Planning Supporting Statement : 23 Linksway Notthwood HA6 2XA

Proposed Revisions to Approved Plans & comments received at Pre-Application taken into account

Drawing Title: Tree Protection Plan

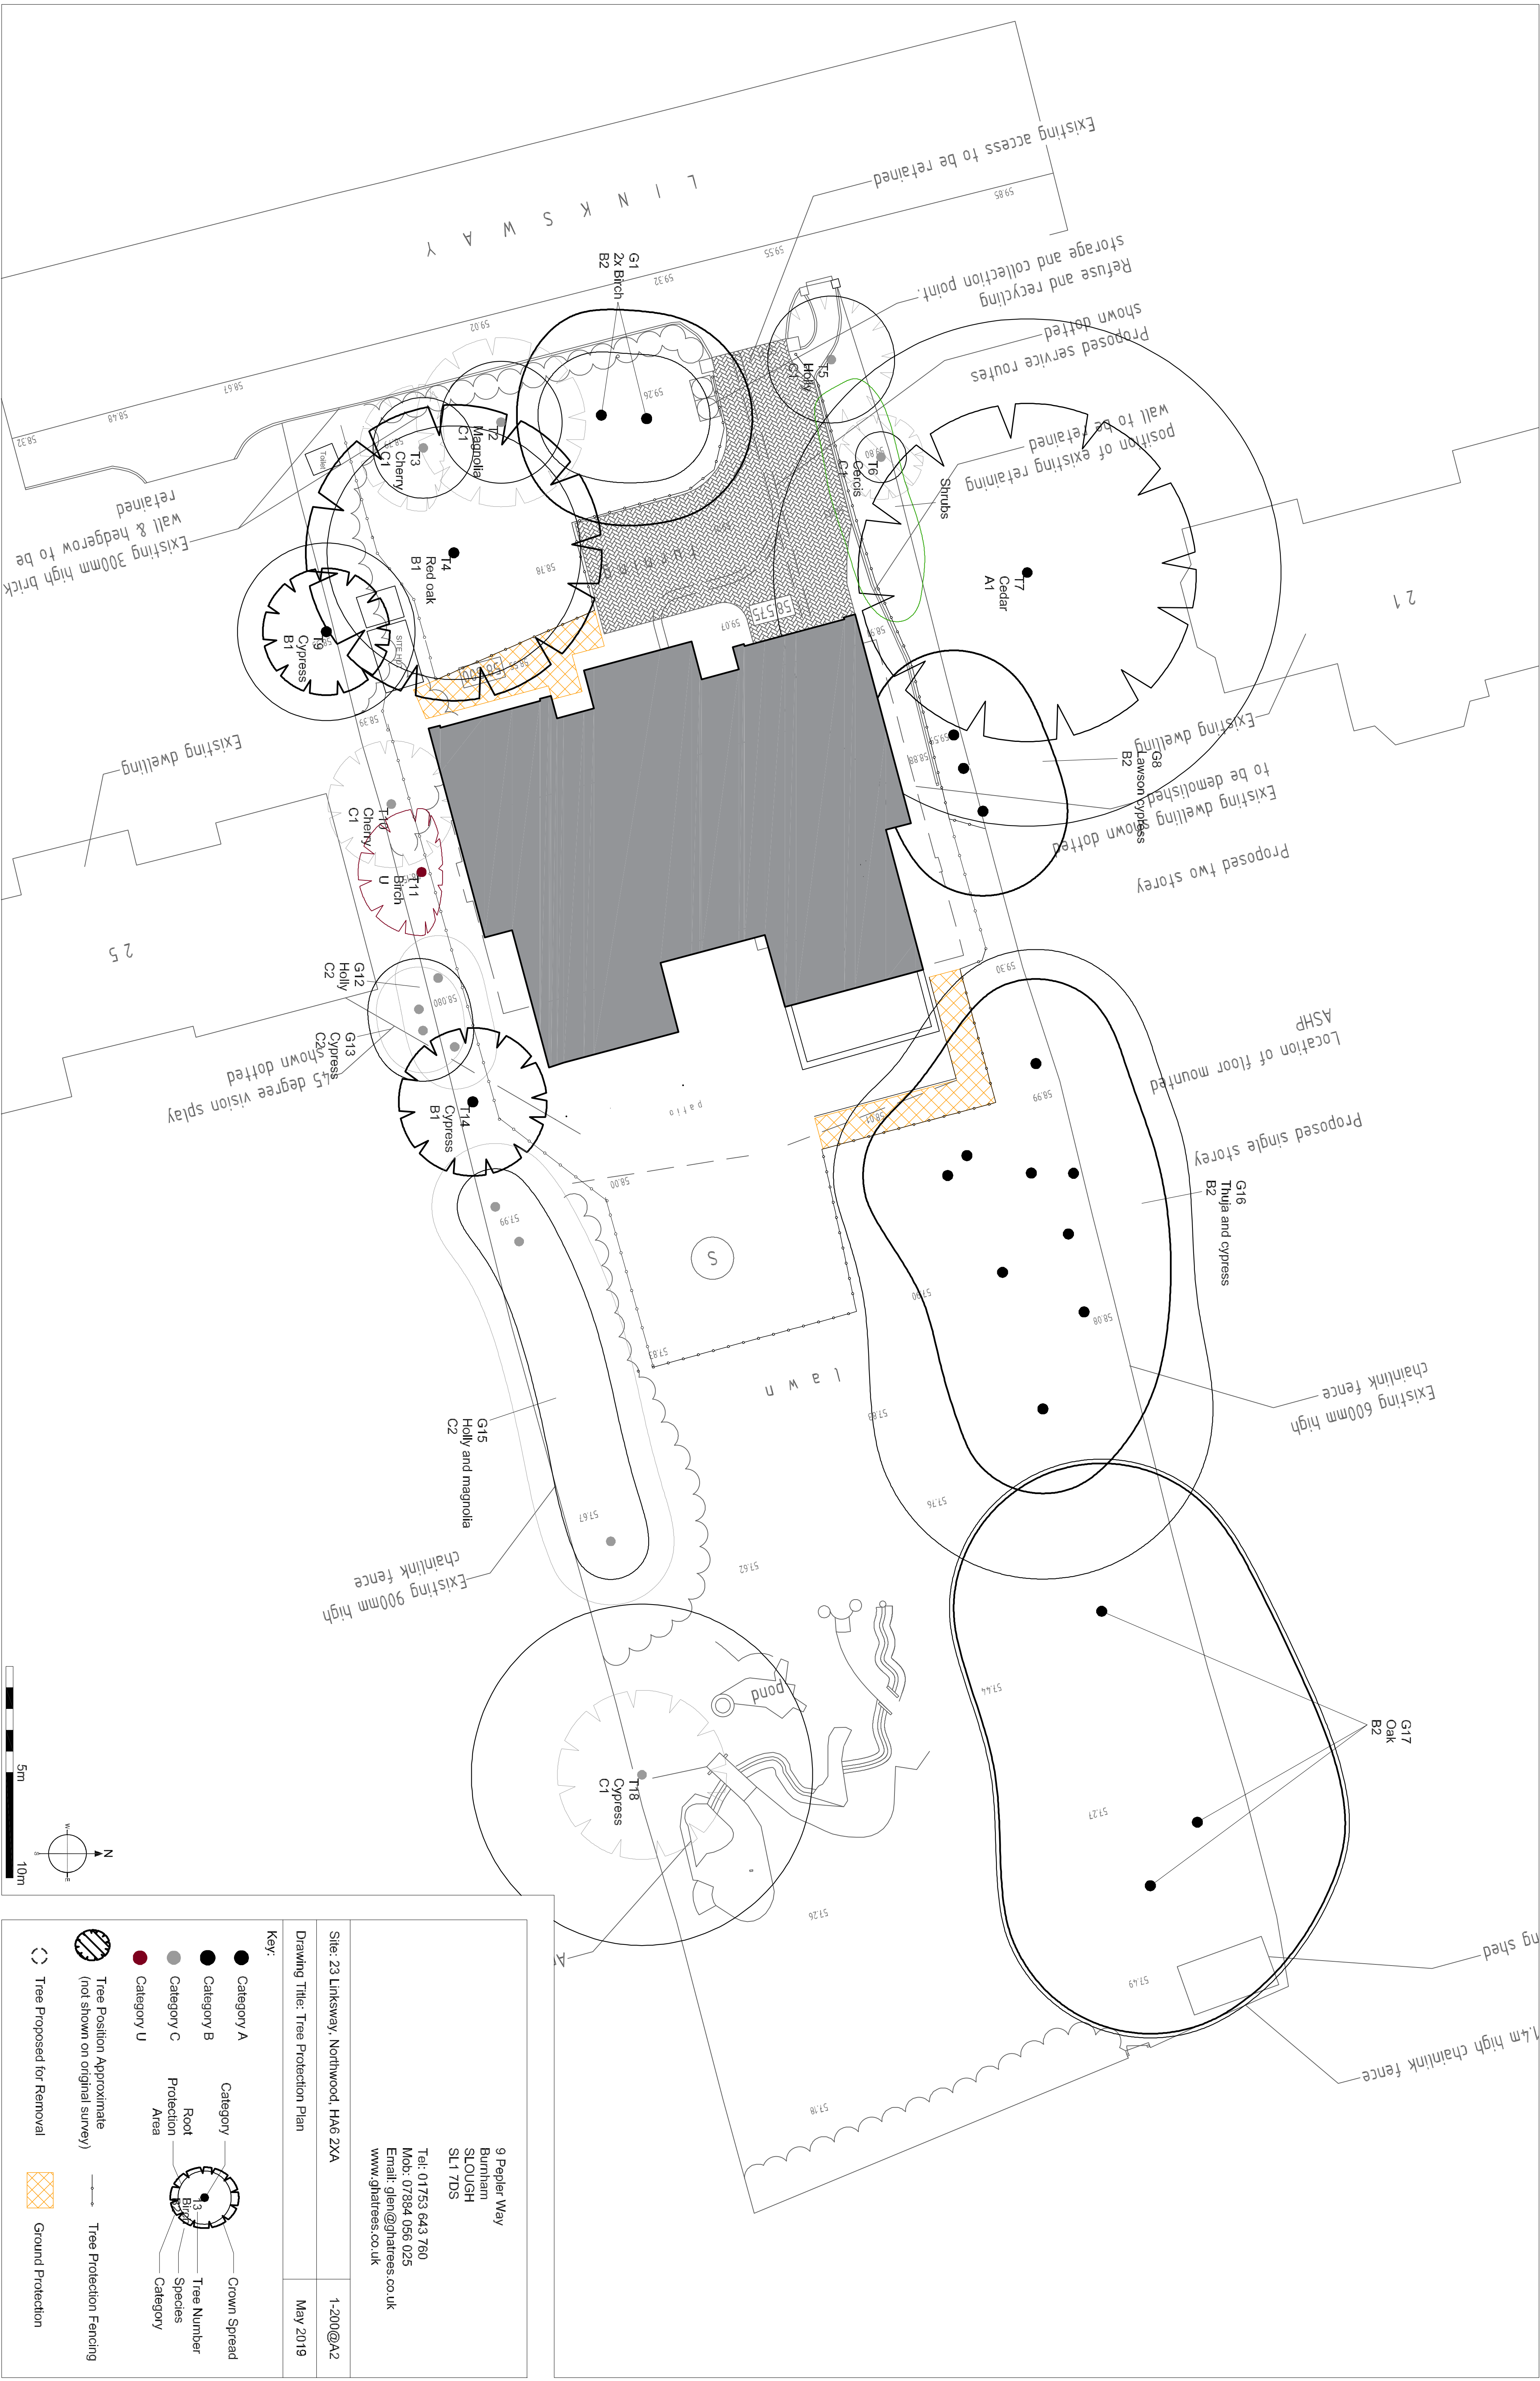
To do this the previous approval had 5 TPO earmarked to be removed which ARE NOW TO BE RETAINED .
